Responses to comments for: K15D011

COAL FLAT APARTMENTS
 1203 COAL AVENUE SE
 ALBUQUERQUE, NM 87107

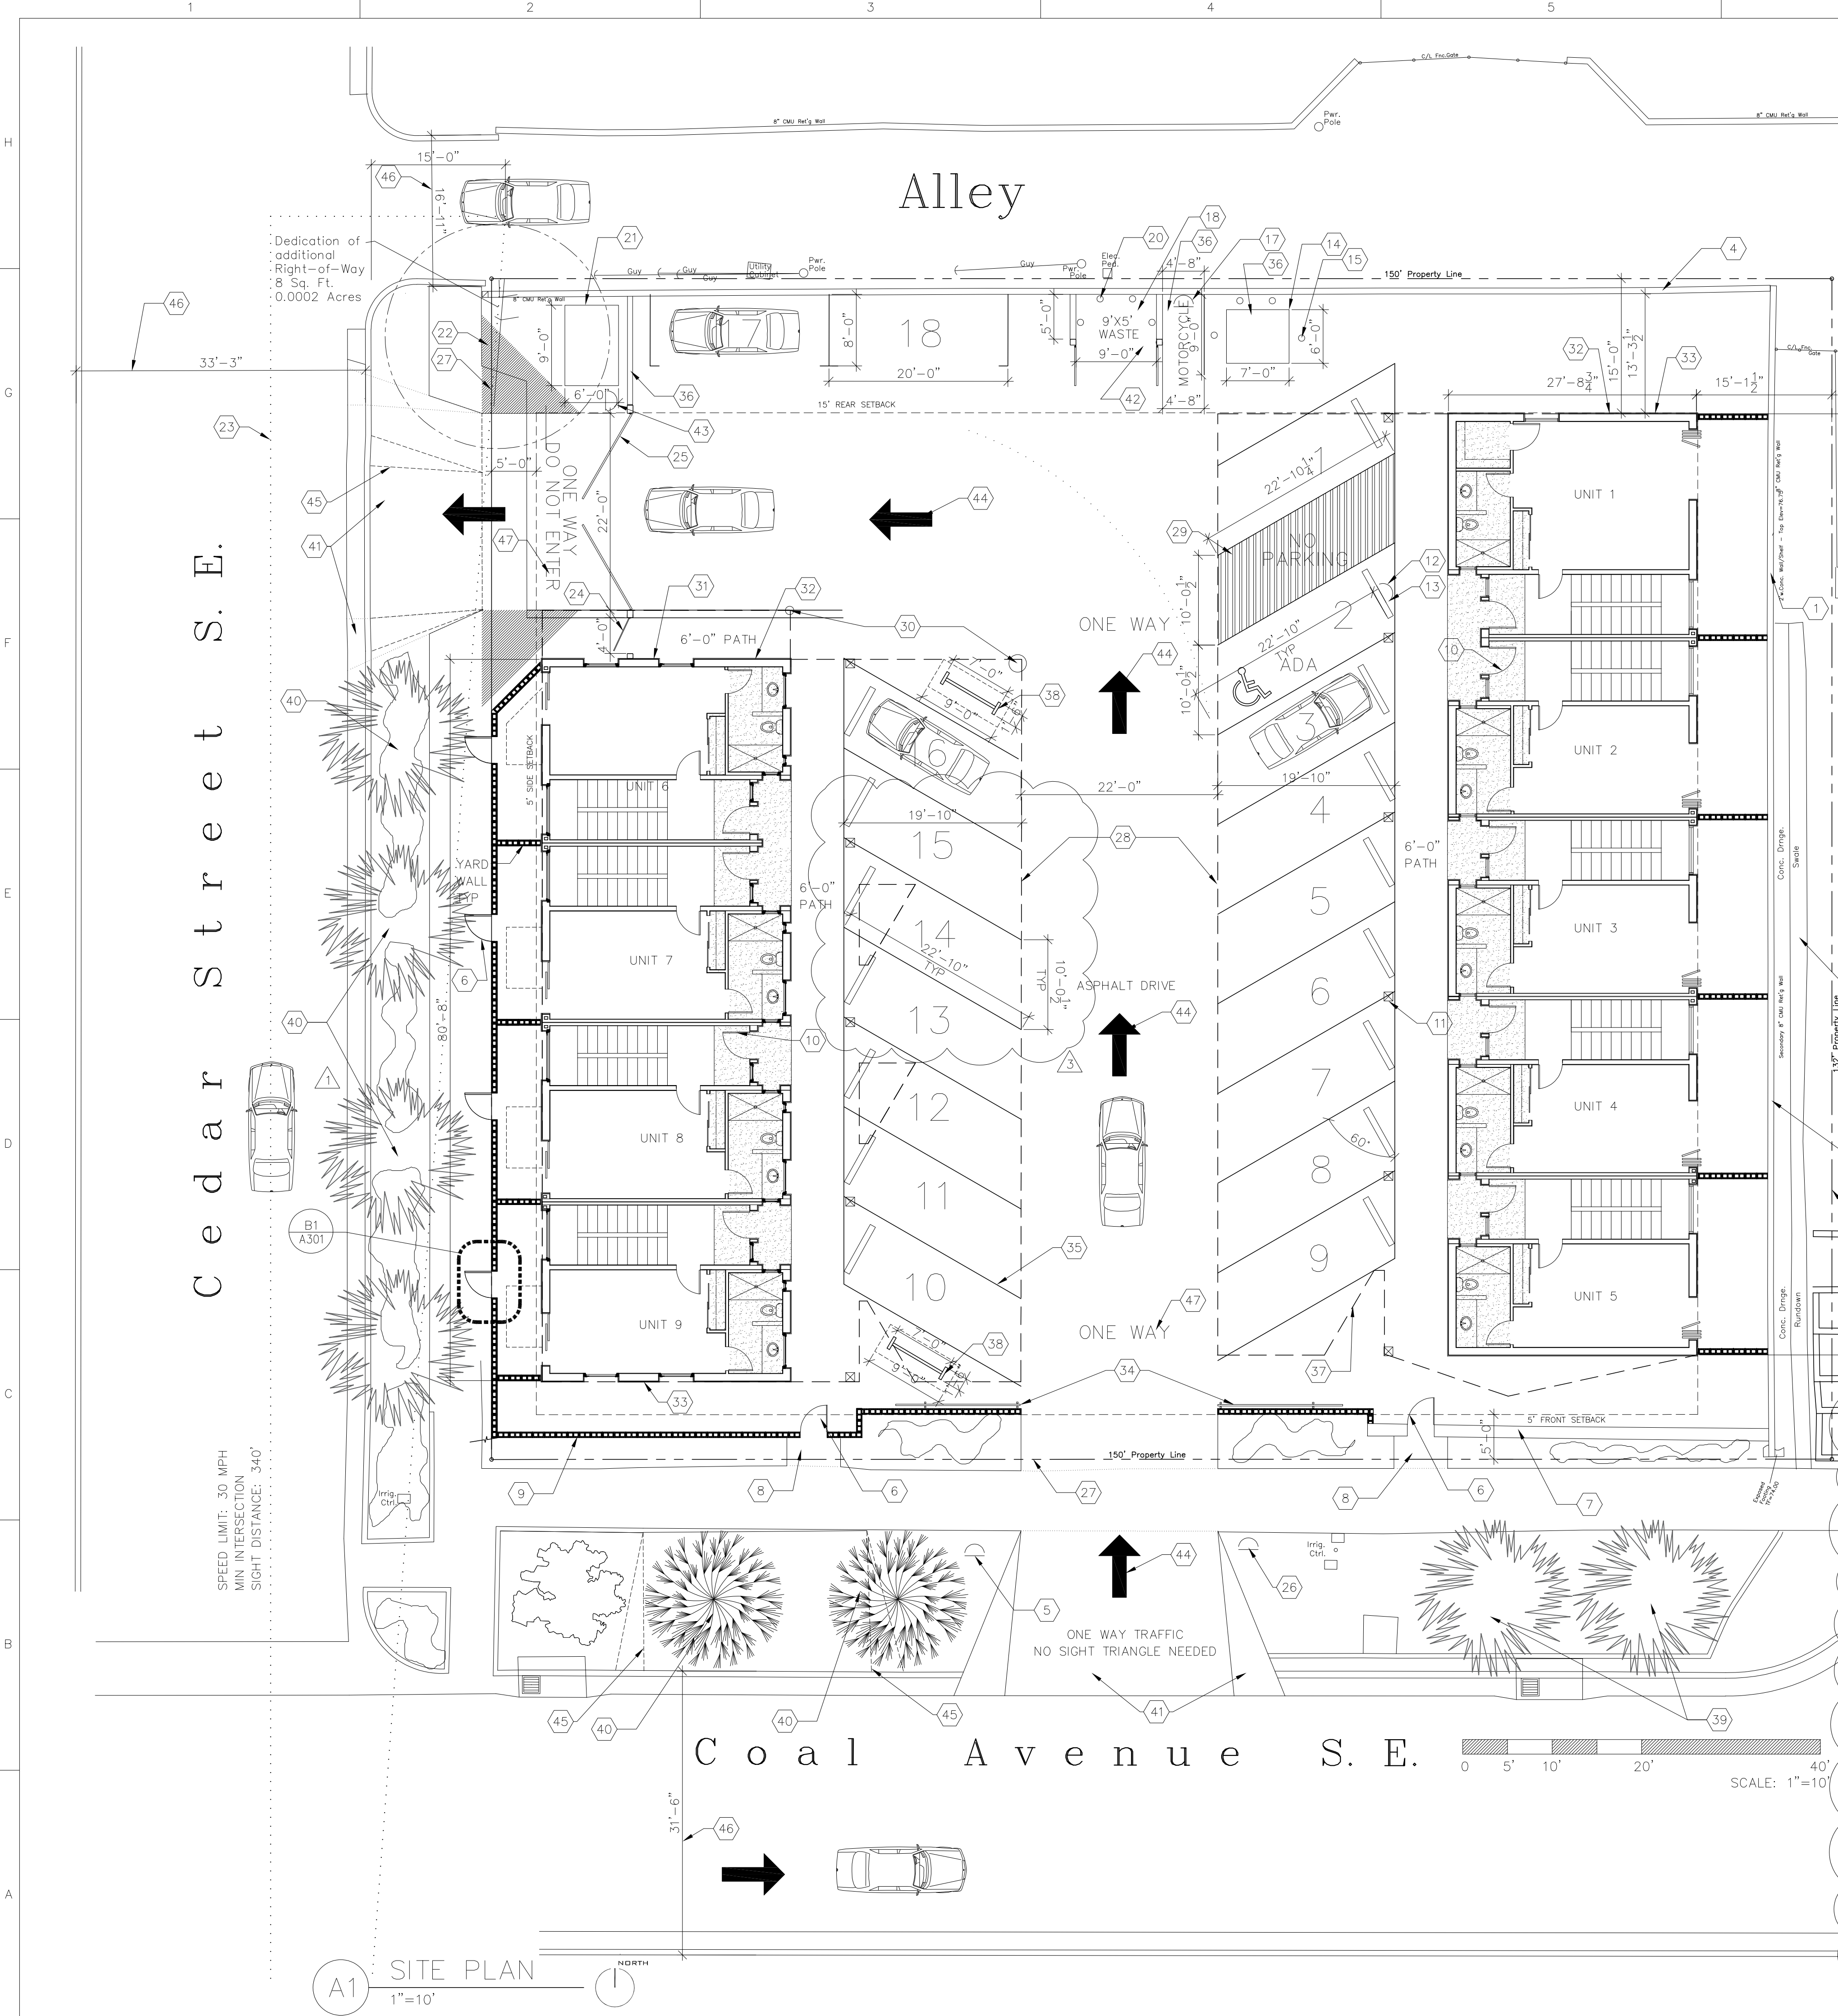
1. Widths for Alley, Coal and Cedar identified. Letter from Cartesian Surveys regarding this comment included in resubmit.
2. Dimensions for parking noted. Clouded with delta 1 marking the update

3. Location of sign with required verbiage noted on plan. Clouded with delta 1 marking the update.
4. Note included on plan. Clouded with delta 1 marking the update

5. Upright sign will be provided. Note indicating the sign. Clouded with delta 1 marking the update.
6. Notes included on plan indicating Bicycle rack requirements. Clouded with Delta 1 marking the update.

7. Note included on plan. Clouded with delta 1 marking the update.
8. Bicycle locations updated to meet this requirement. Clouded with delta 1 marking the update.

13. One-way Drives will have indicated signage. Note included on plan. Clouded with delta 1 marking the update.
14. Note included on plan. Clouded with delta 1 marking the update.

17. Modifications to drive and trees do not meet the minimum standard for this comment. (per Matt Grush) Driveway pads being shut down are noted on the plan. Trees being replaced/added are noted on plan. Clouded with delta 1 marking the update.
